**Consultation Response from KC,
Trees**

2026/90728 Windy Gap Farm, Little Lepton, Green Balk Lane, Lepton, Huddersfield, HD8 0LN

Removal of agricultural building and erection of detached dwelling

Date Responded: 8/4/26

Drawing Title:	
Tree Constraints Plan	
Site Address:	
Windy Gap Farm Green Balk Lane Lepton	
Client:	
SBP Architect	
Date:	Job Ref:
11/03/2024	TCC- 1903-1
Scale:	Revision:
1:500 at A4	1

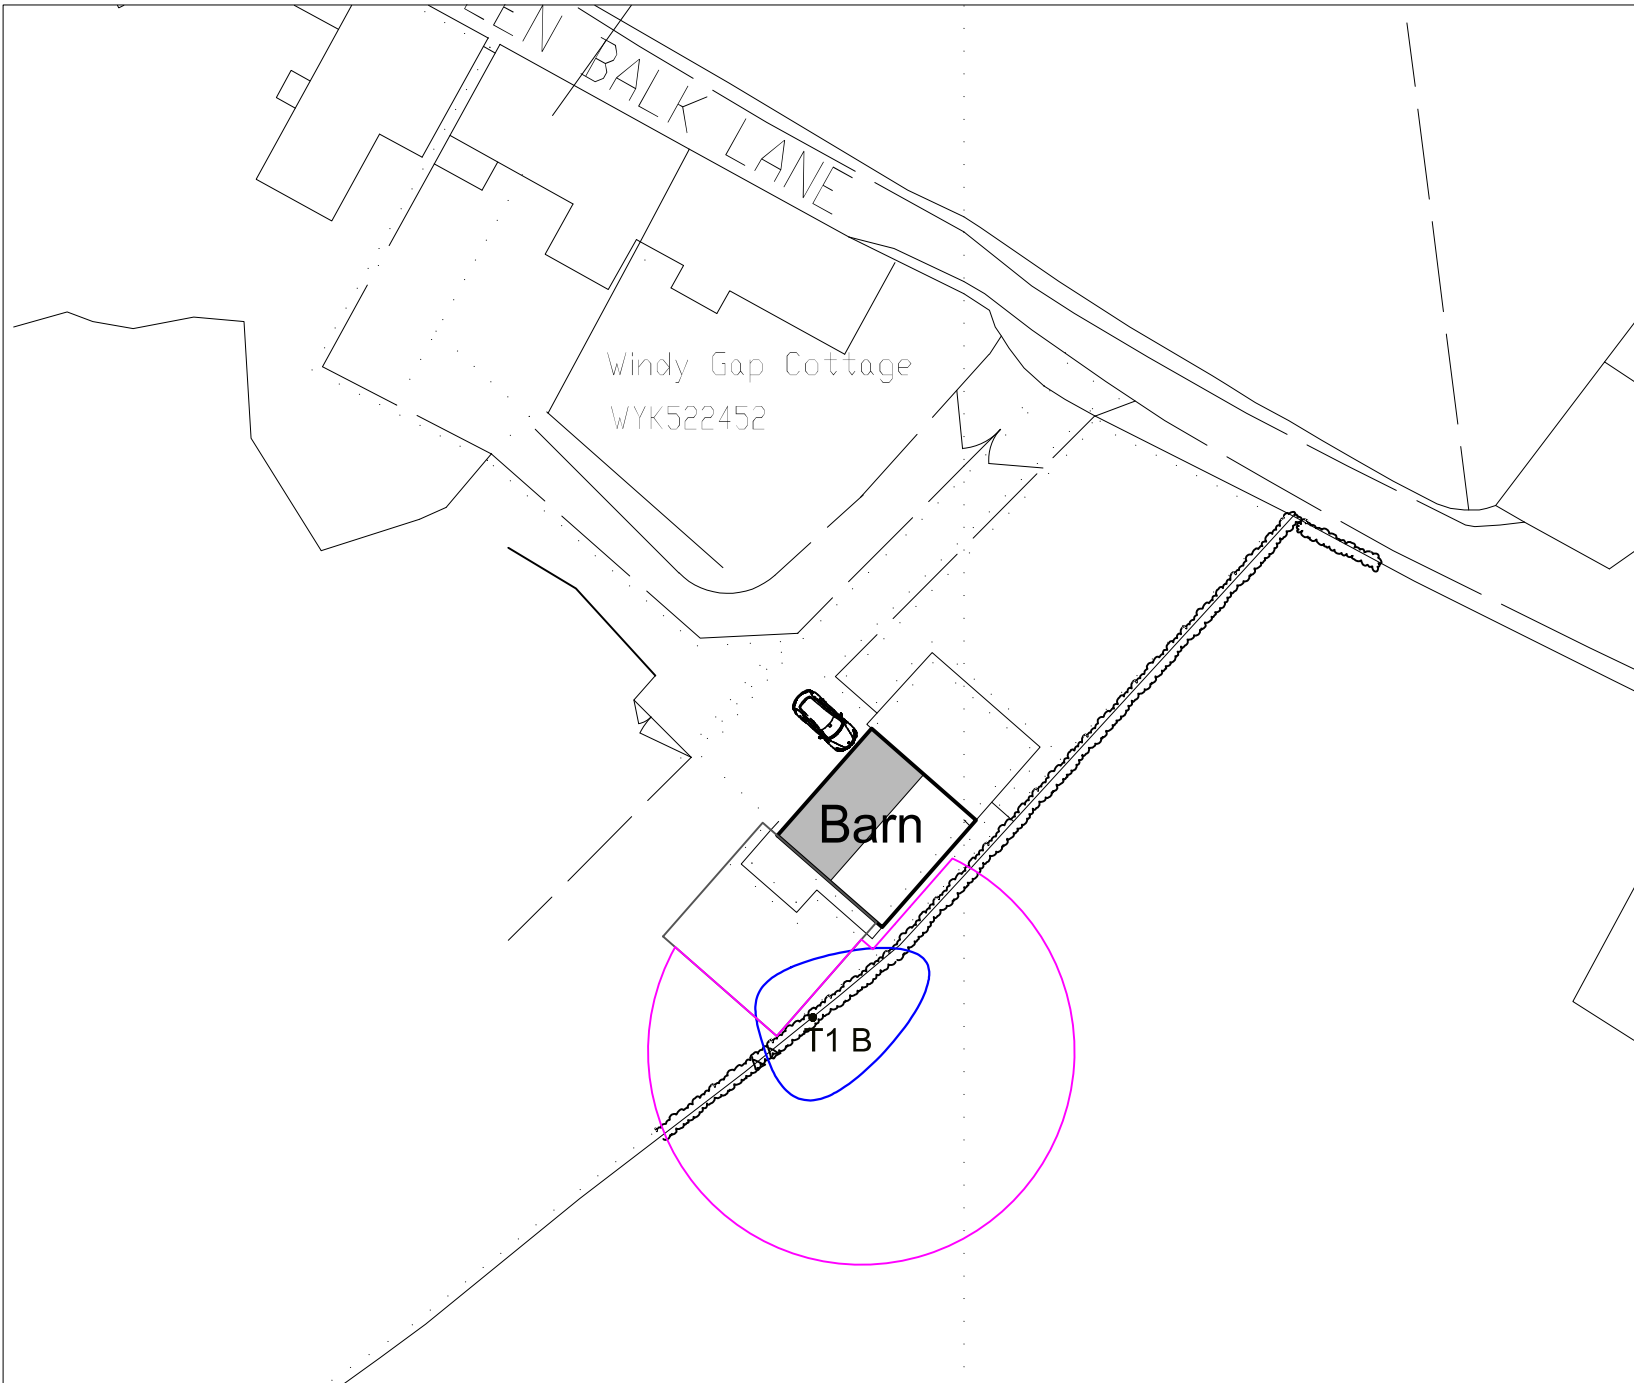
On the aerial imagery, the large, round canopy (approx. 16m across) extends to the southwest corner of the existing barn but is not shown as such on the drawings. The survey schedule notes pruning to create 2m clearance from the barn, but this would not explain why the canopy appears significantly smaller on the plans. Canopy conflicts are an important consideration particularly in this case as demolition and construction operations cannot be excluded. Please amend the constraints information to show the correct canopy size.

Appendix 5
Tree Impact Plan

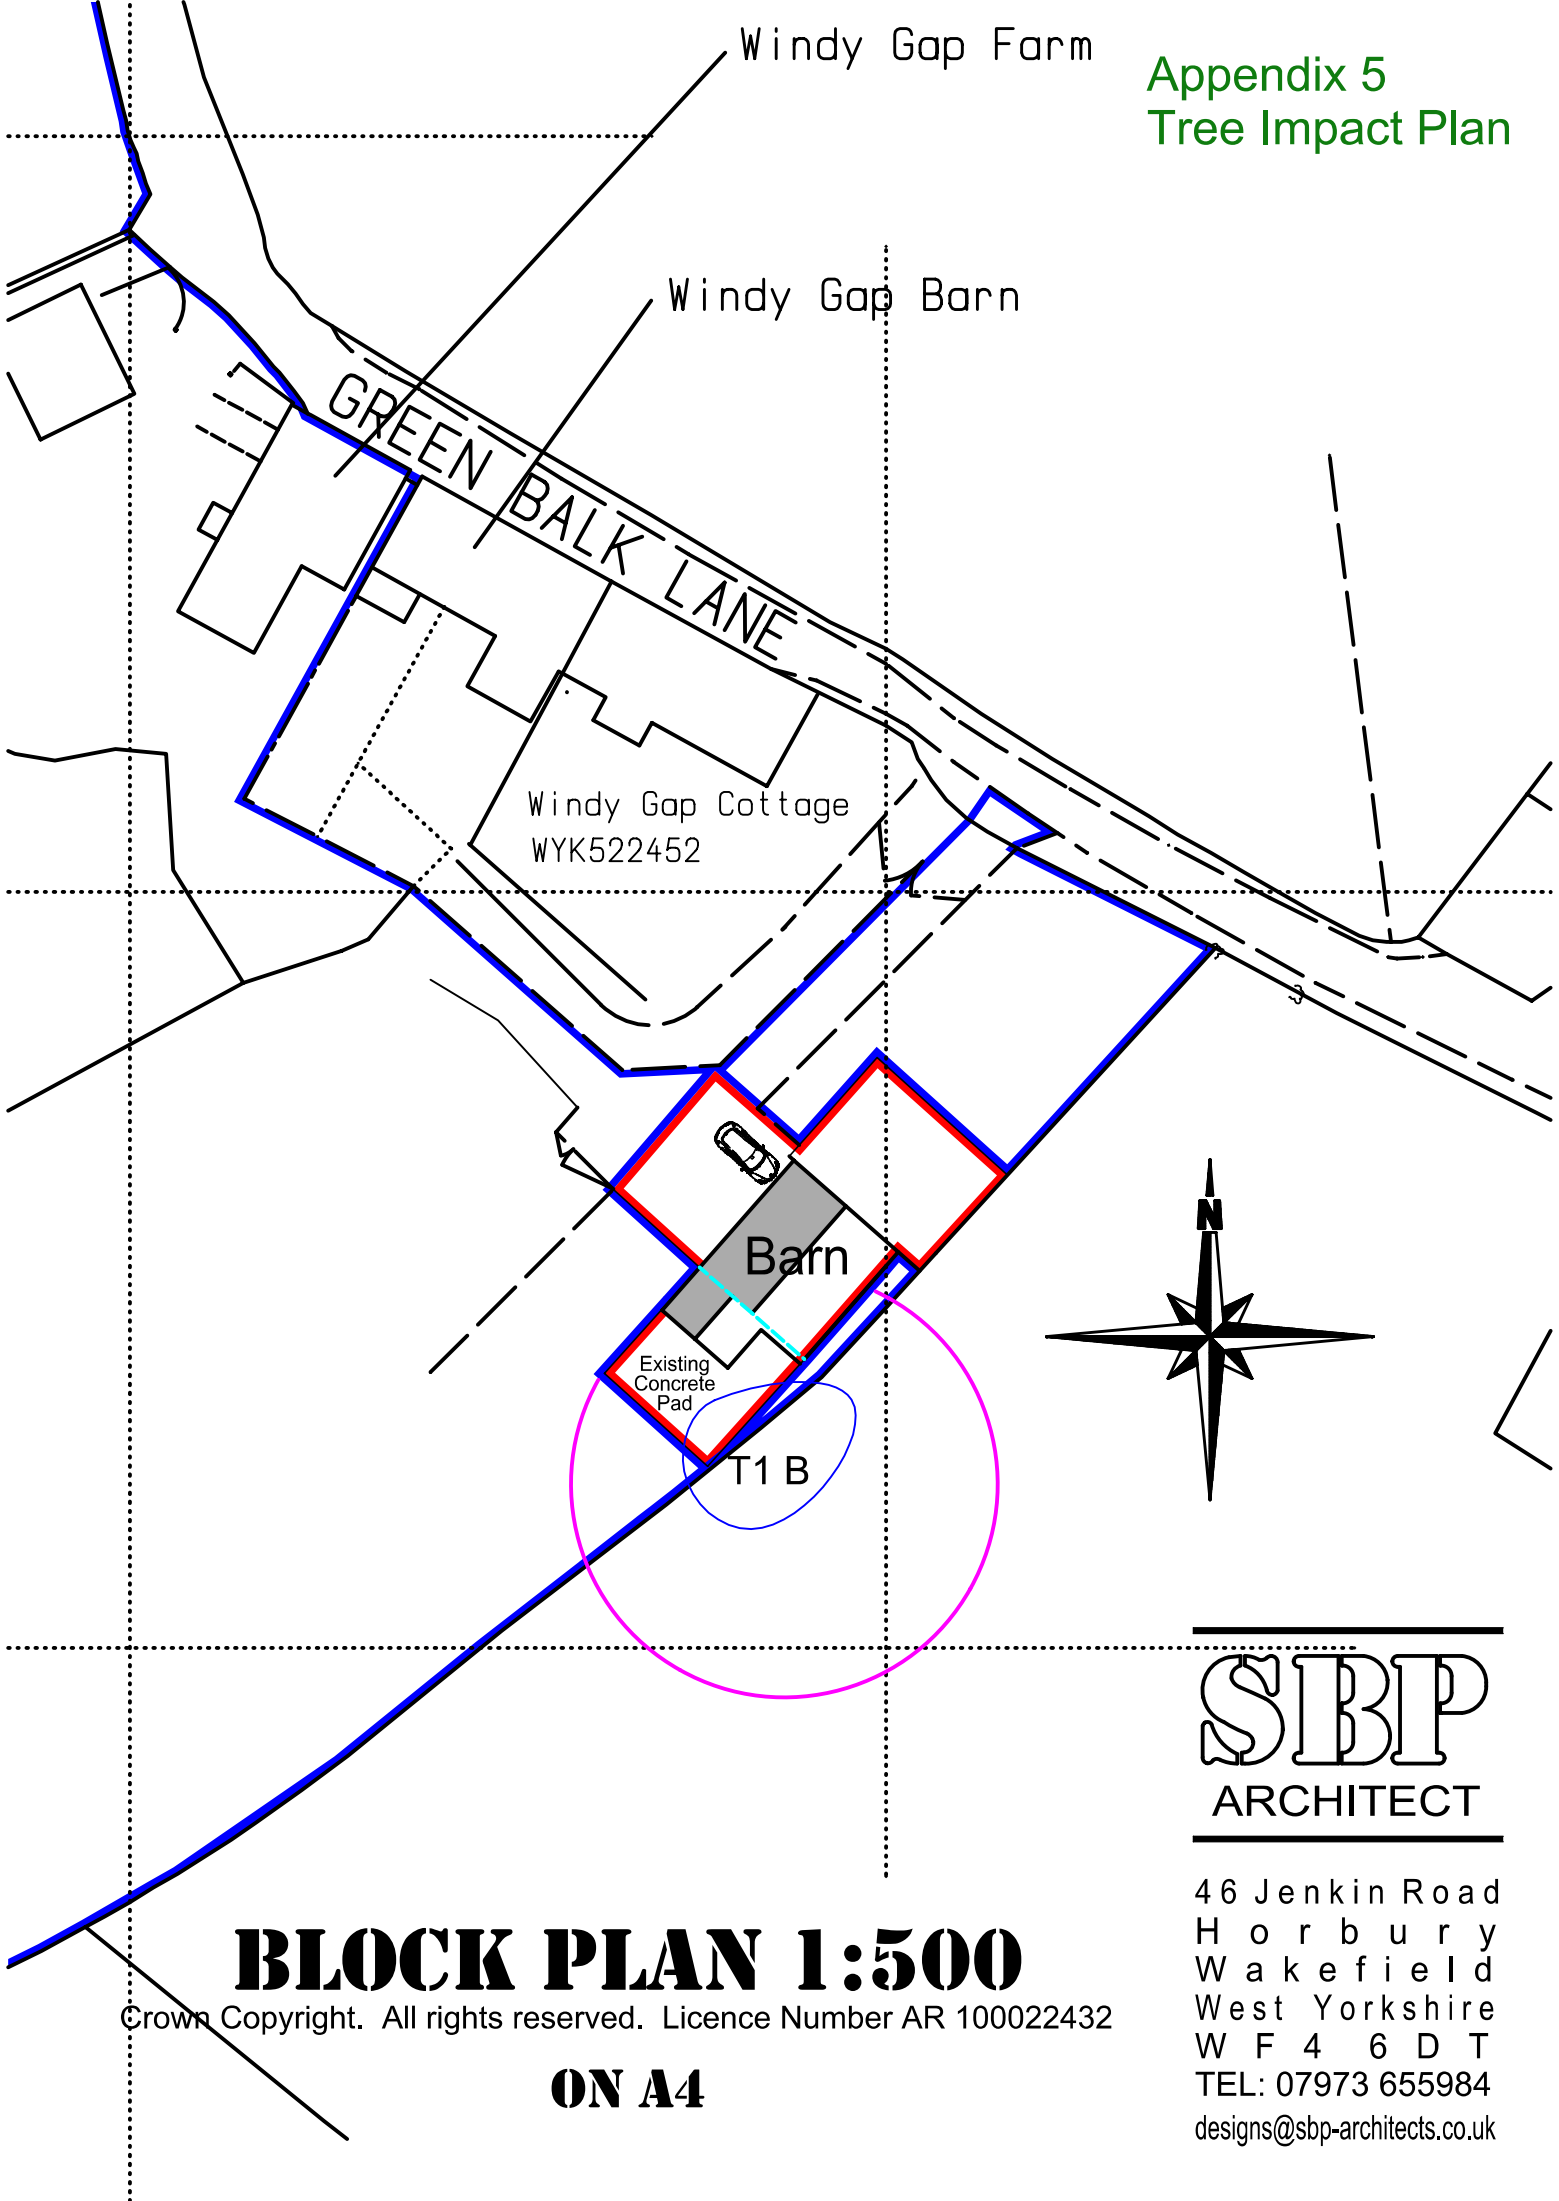
If the structure is sited as currently proposed, it would be well within the RPA and at the edge of the canopy line. The tree would be threatened with removal as the future occupiers would face foreseeable issues of nuisance and shading associated with living within the shadow of a large, mature oak. The proposal conflicts with Local Planning policies. LP33 requires that proposals do not directly or indirectly threaten trees or woodlands of significant amenity value.

It is the view of KC Trees that the proposals should be revised to set back the proposed dwelling from the tree to avoid any foreseeable conflicts and create a more enjoyable property.
